Sent: 10 November 2009 10:53
To: Planning
Subject: Comments Added: 69 Northaw Road East, Cuffley

Application ID: S6/2009/1922/FP Mr D Manhertz Application Owner: Welwyn & Hatfield
Borough Council (Development Control Officer)

Location: 69 Northaw Road East, Cuffley

Description: ERECTION OF SINGLE STOREY OUT BUILDING FOR USE AS GYM

Drawing N°: ELA/6 Rev: 00

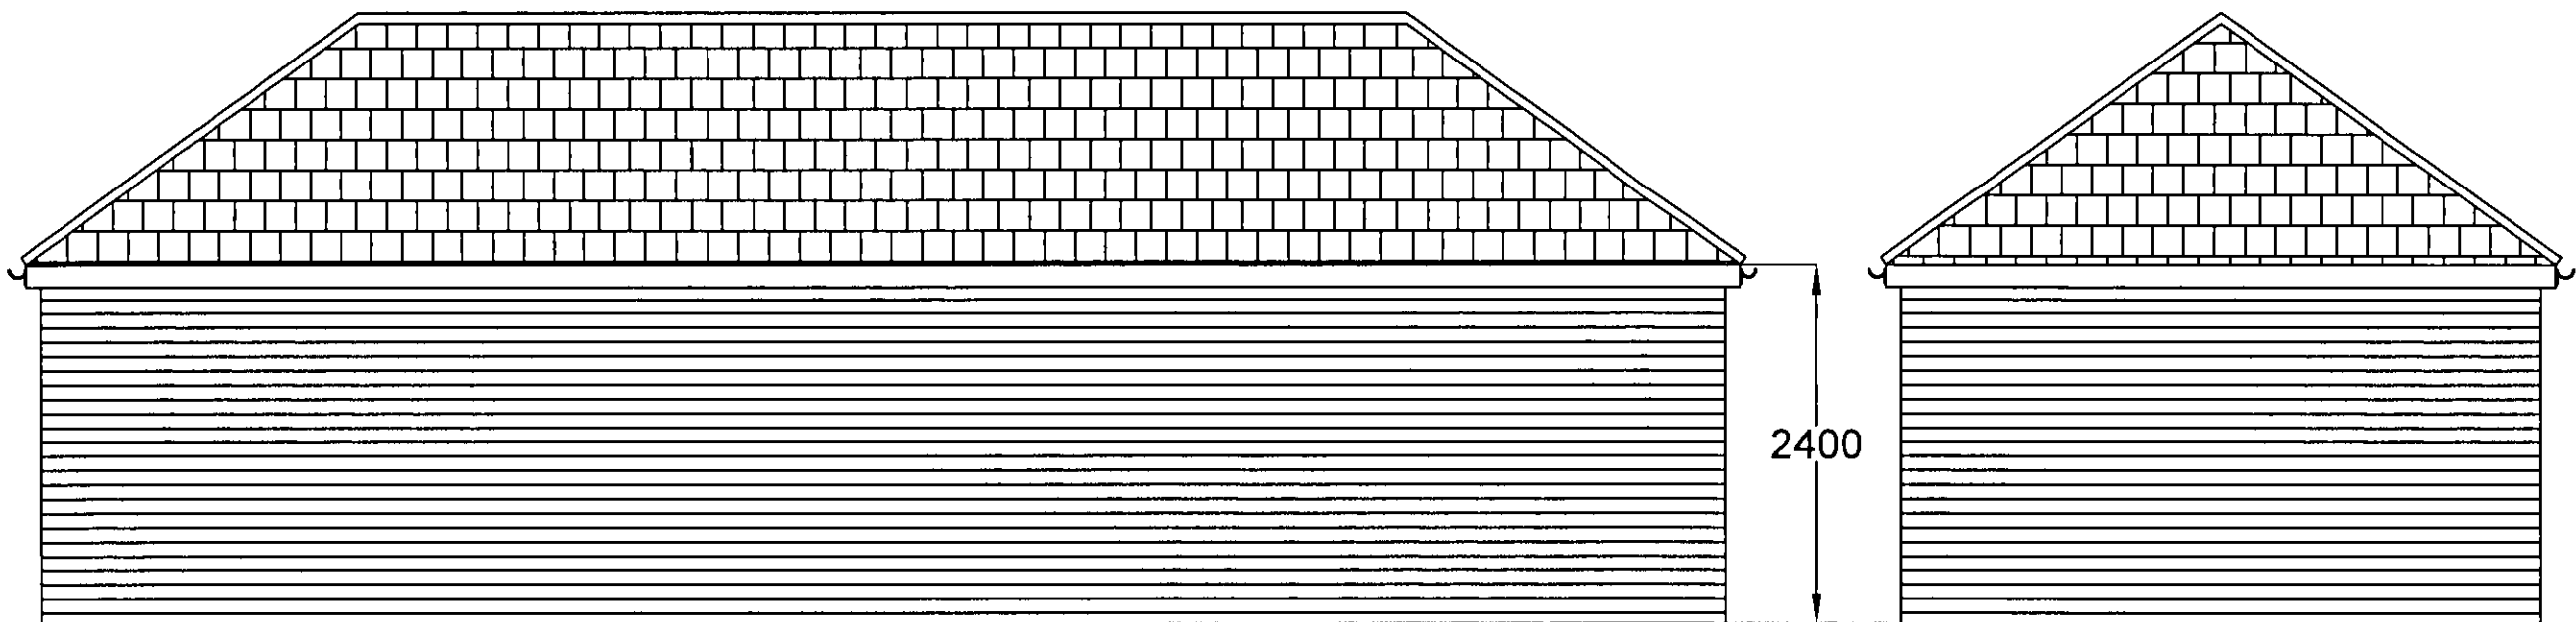
Comment: This seems to be a large building backing onto open ground and may be
intrusive to the landscape
